Our ref: AN/2023/135168/01-L01
Your ref: H16-1096-23

Date: 10 January 2024

**Proposed anaerobic digester plant
Land between A16 and Rangell Gate Spalding**

Figure 10 - Foul Connection into Matmore Gate

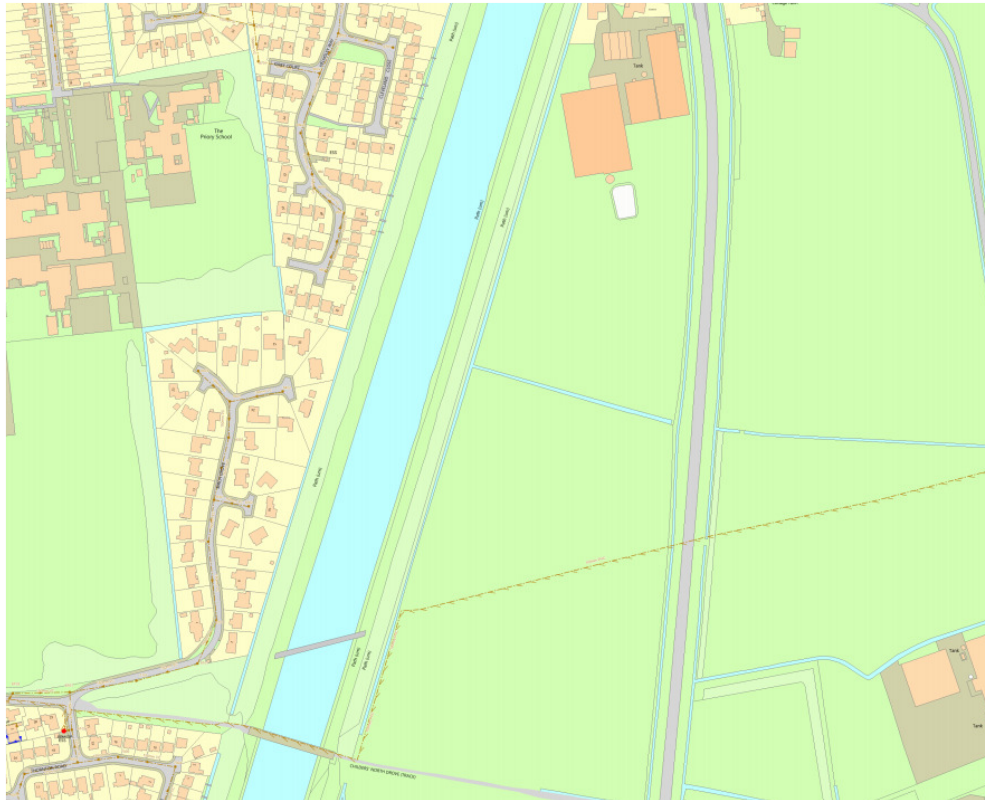
We **object** to the proposed development as submitted because it involves the use of a non-mains foul drainage system in circumstances where it may be reasonable for the development to be connected to a public sewer, but no justification has been provided for the use of a non-mains system.

In this instance no justification has been provided by the applicant for non-connection to the mains sewerage system.

To overcome our objection the applicant should thoroughly investigate the possibility of connecting to the public foul sewer, and either revise their application to propose a mains connection or submit evidence that demonstrates that this is not feasible.
